January 7, 2022

Subject: **Request for Modification for Section 404 Regional General Permit No. 201902350 and Section 401 Water Quality Certification** for the Proposed I-485 and East John Street – Old Monroe Road (SR 1009) Interchange Improvements, Mecklenburg County, Division 10, STIP U-4714AB. Debit \$570.00 from WBS 43609.3.2.

Permit Impact Site Modifications (shown in revised permit drawings):

PERMIT DRAWING  
SHEET 11 OF 17

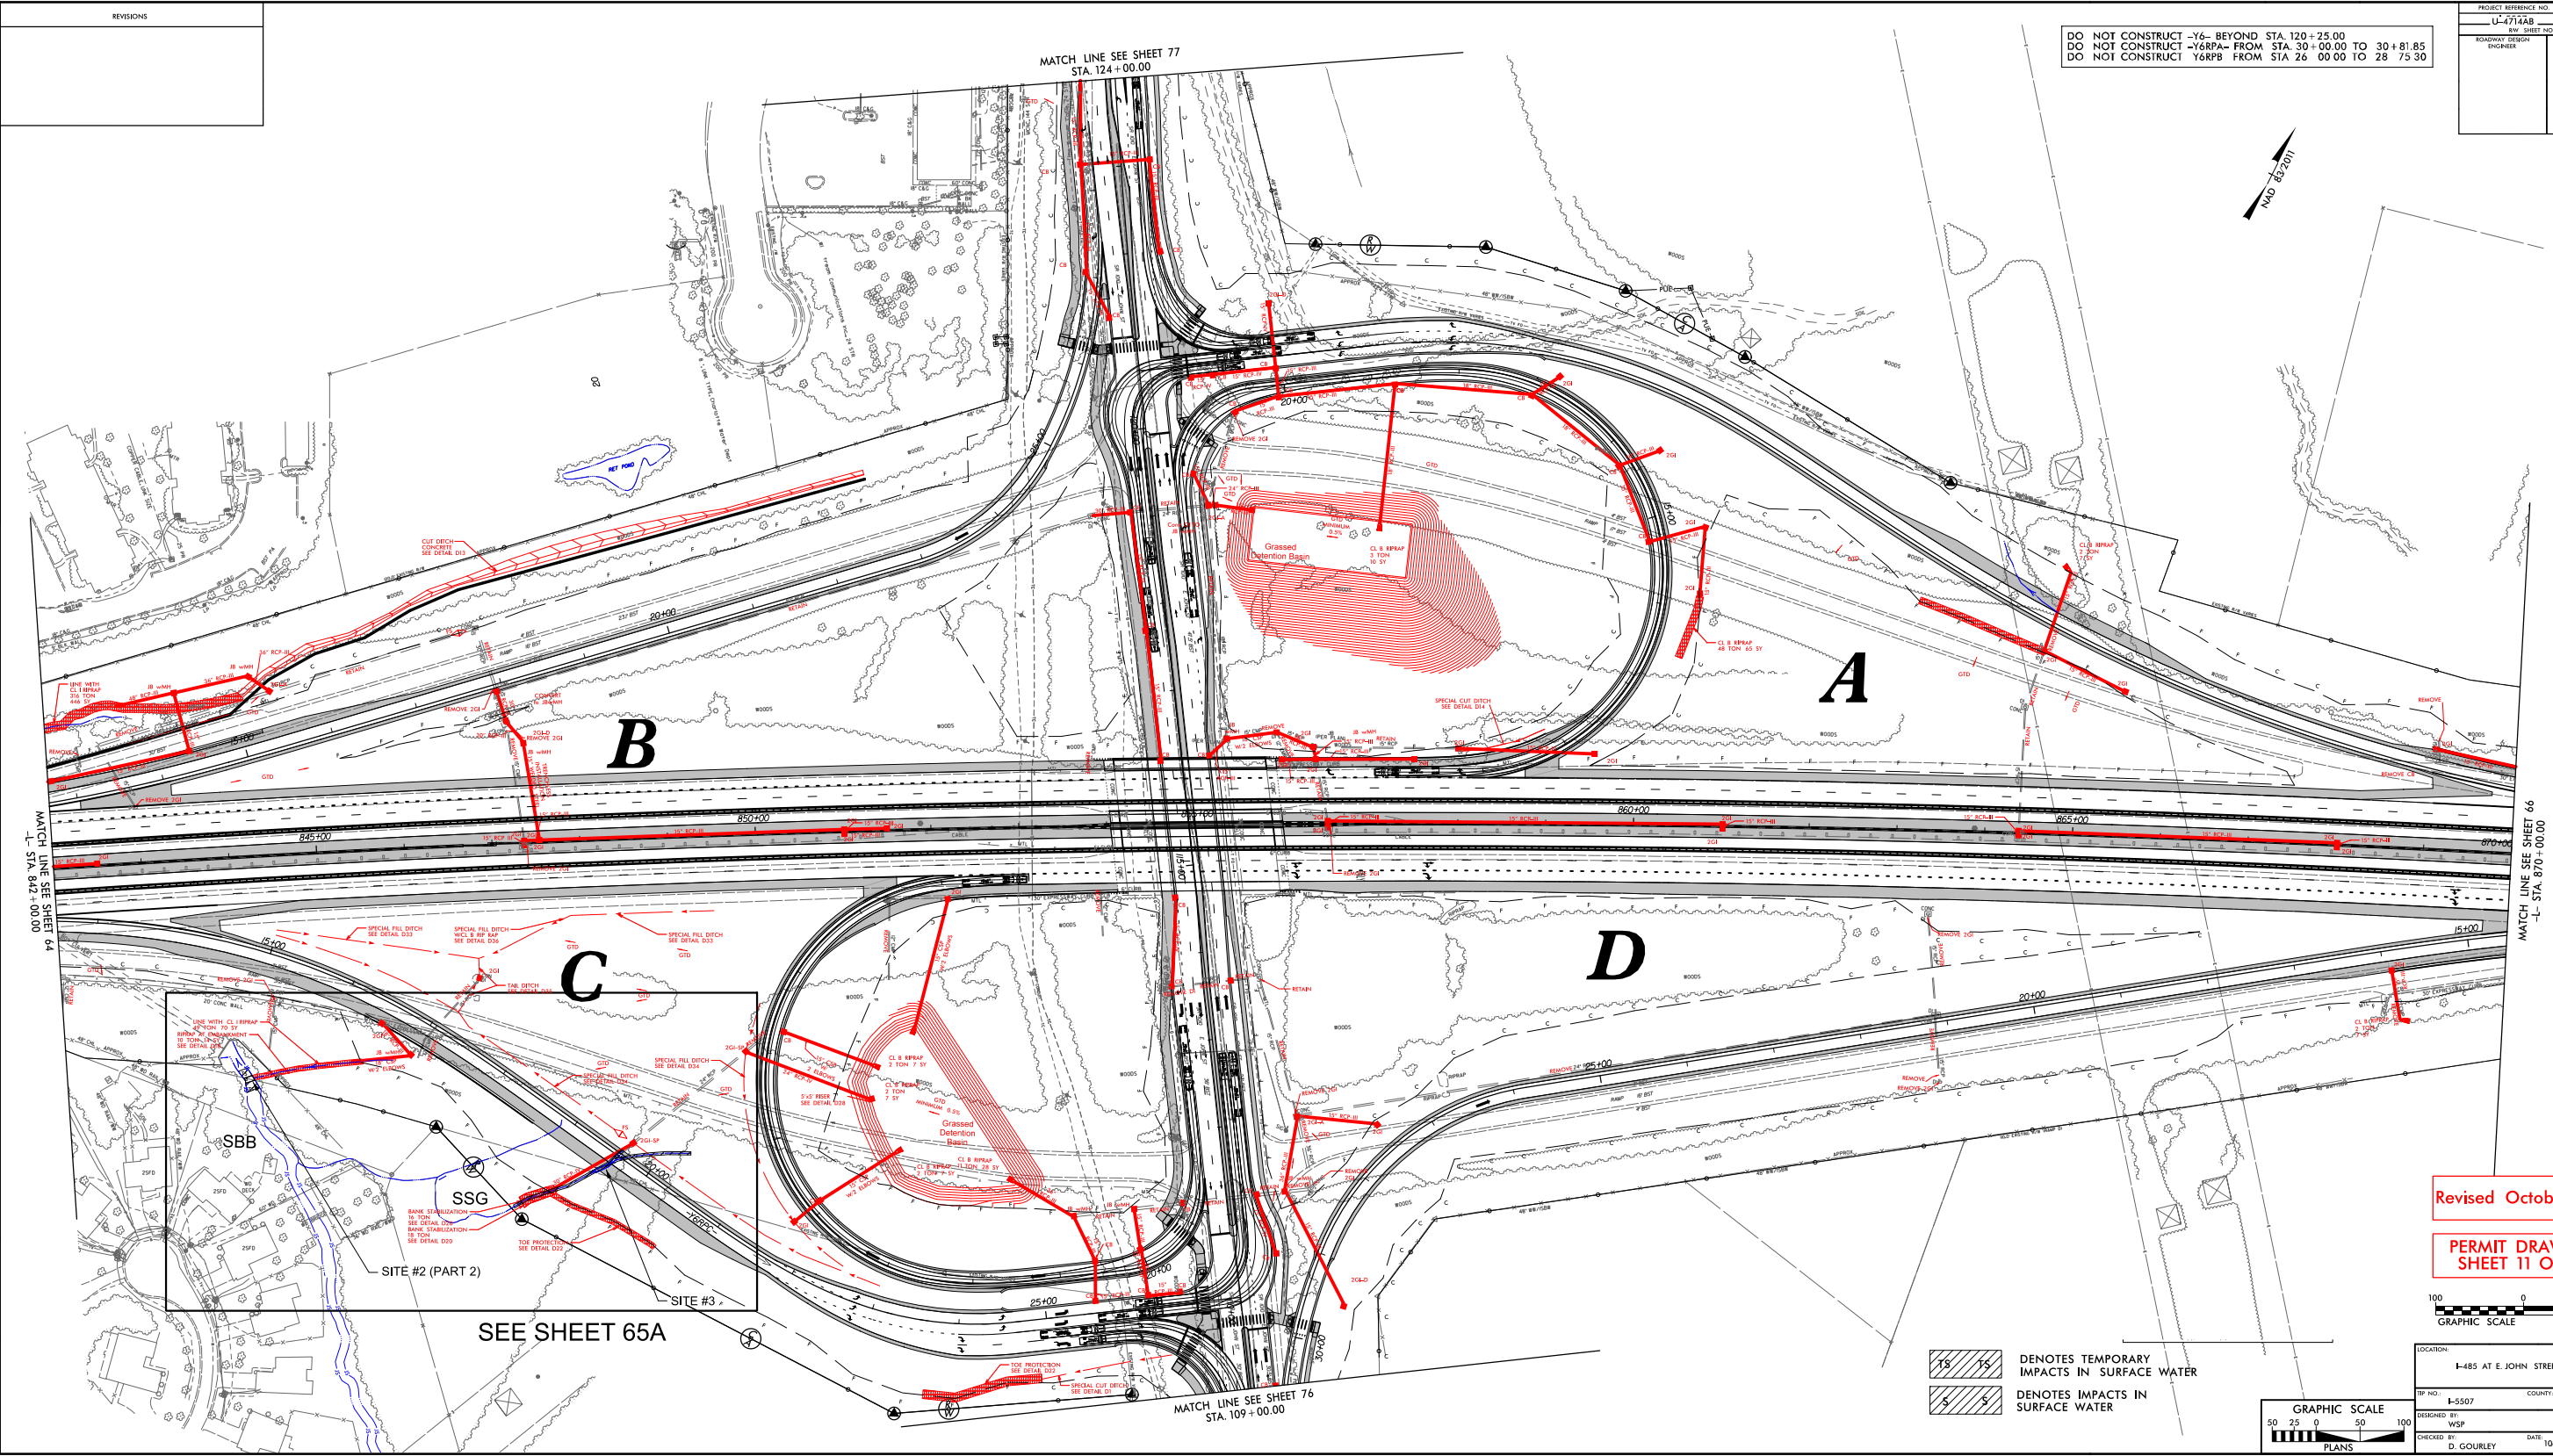
Site 3

The original design included 197 linear feet of permanent stream impact to stream SSG resulting from the installation of 30-inch and 15-inch reinforced concrete pipes (RCP) for drainage, 31 linear feet of permanent bank stabilization impacts, and 10 linear feet of temporary stream impacts.

The design has been revised to include ditch drainage along the exit ramp rather than a closed drainage system in this location. In the revised design, the 15-inch RCP has been eliminated and the upper reach of stream SSG will be filled and drainage will be captured in a new roadside ditch before draining into the previously-approved 30" RCP. The new design includes 197 linear feet of permanent stream impact, including 100 linear feet of impact from installation of the 30" RCP and 97 linear feet of roadway fill impact. Bank stabilization will remain at 31 linear feet and temporary stream impacts will remain at 10 linear feet. The proposed design will result in no change to the length of permanent or temporary stream channel impacts.

SHEET NO.  
77-1

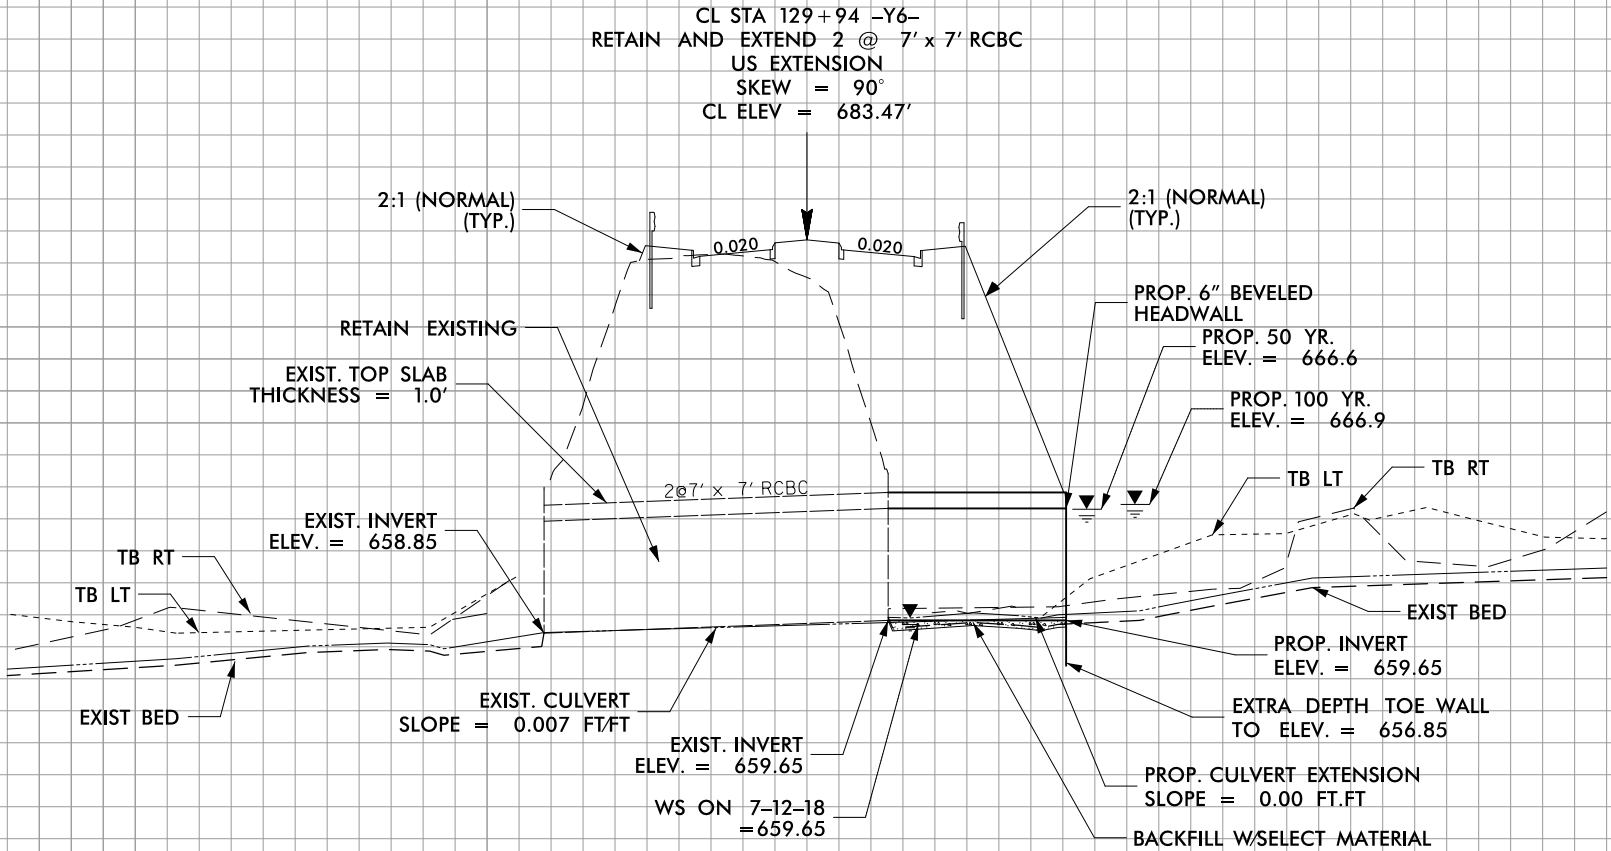
Site 4

The original design included 26 linear feet of permanent stream channel impacts from bank stabilization and 24 linear feet (<0.01 acre) of temporary stream impacts to stream SAG (Four Mile Creek).

The design has been revised to extend the widening of East John Street to the north and includes construction of the intersection of the future Greylock Ridge Road Extension (Project No. HL-0025) on the east side of East John Street. This will result in the need to extend the dual 7x7 reinforced concrete box culvert (RCBC) beneath East John Street at stream SAG (Four Mile Creek). This project modification is being proposed to alleviate future traffic congestion at the I-485 interchange at East John Street, simplify traffic control for the public in this area, and minimize the risk of sedimentation into stream SAG.

The new design includes 56 linear feet of permanent stream channel impacts resulting from the dual 7x7 RCBC extension, 42 linear feet of stream bank stabilization impacts, and 56 linear feet (0.06 acre) of temporary stream impacts. The proposed design will result in an increase in permanent stream channel impacts of 72 linear feet (including an increase of 16 linear feet of stream bank stabilization impacts) and an increase in temporary stream impacts of 32 linear feet (0.05acre).
